Your Ref: OWPC17769
Our Ref: AW/55/18/HH 14-02-2018
Please ask for:
Mr S Davis

Rear and side, single and two storey extension incorporating rear balcony. This application affects the Character & Appearance of the Aldwick Bay Conservation Area
3 The Orchard Aldwick

Thank you for your internet representation made on 2nd April 2018 which has been recorded as '**an objection**' with the comments as follows:

PROPOSED ELEVATIONS

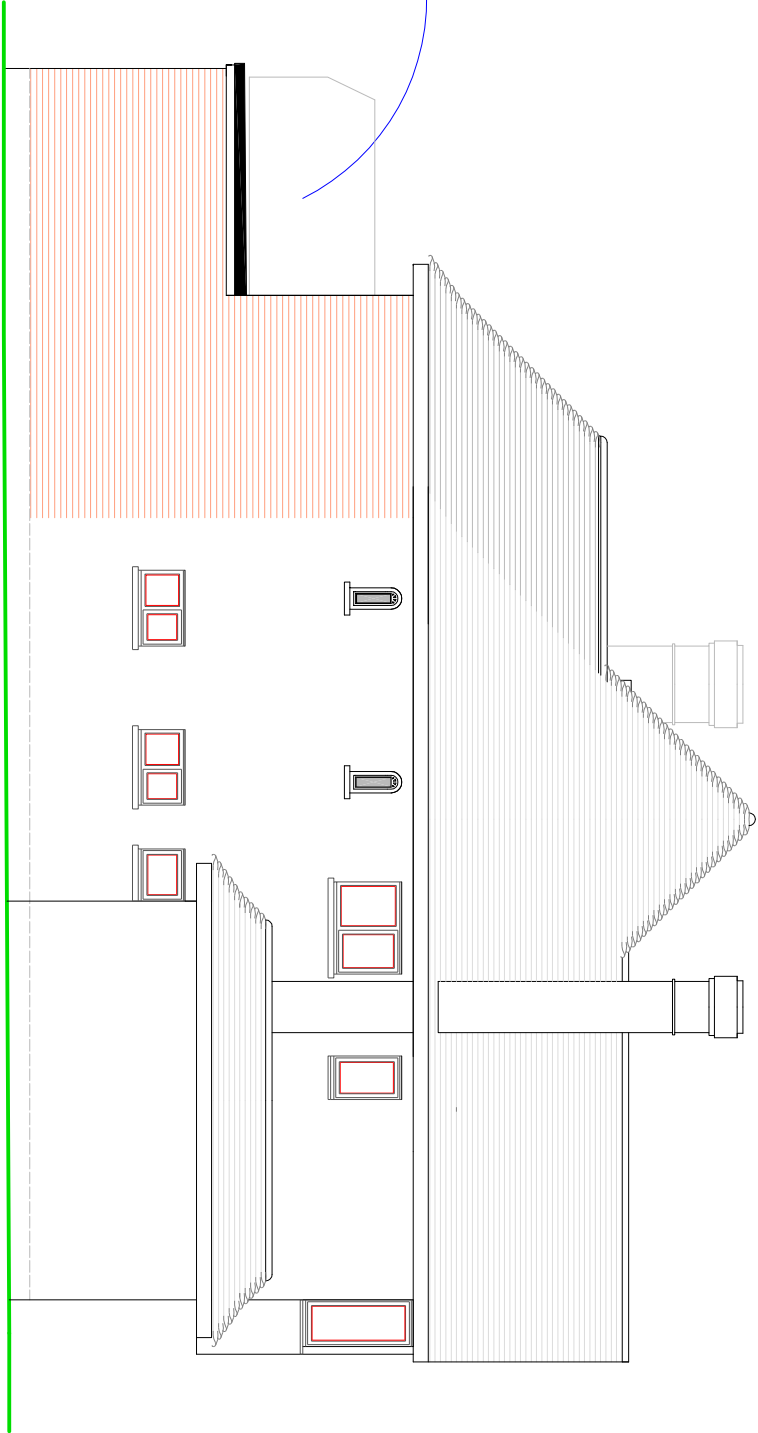
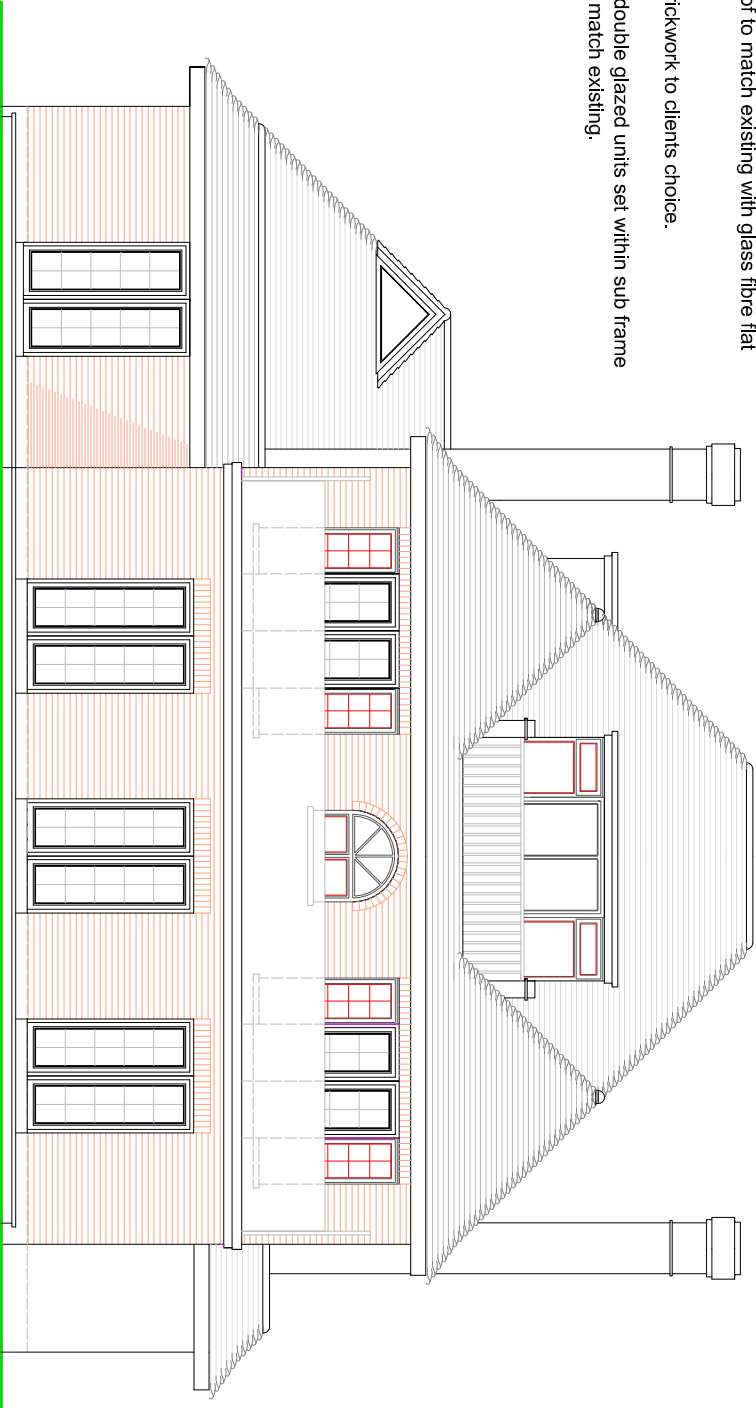
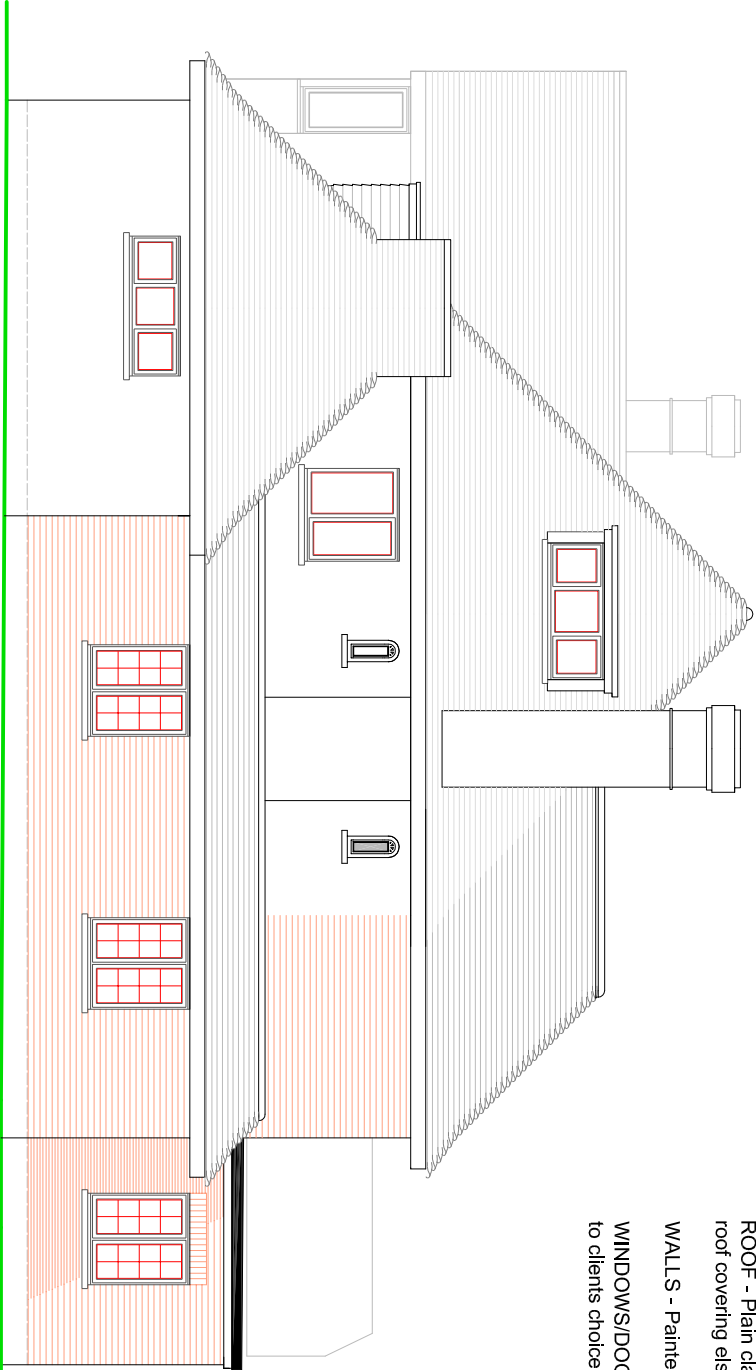
Having looked over the plans and spoken to both the applicants and one of the neighbours, we feel that the project as a whole is agreeable, with the exception of the new balcony. I have spoken to neighbours and viewed the proposed site from their balcony and agree that by extending the current footprint out by approximately eight feet, this would interfere with the privacy of their neighbours. The neighbours who have already opposed the application have done so on this basis but have no objections to the overall project. I spoke again to the applicants and discussed this and they could see the points being raised and will liaise with the neighbours to discuss alternatives. One alternative discussed was having the balcony only on one side from the master bedroom and not proposed bedroom two, this should Alleviate the privacy issue, as long as this was not opposed by the other neighbour, which from the position of the properties may not raise the same privacy issues. The applicants have agreed to look at alternatives and discuss with affected parties to try to come up with an agreeable solution. But on the basis of the current plans, we object on the points raised above. Brian Stanley, planing director.
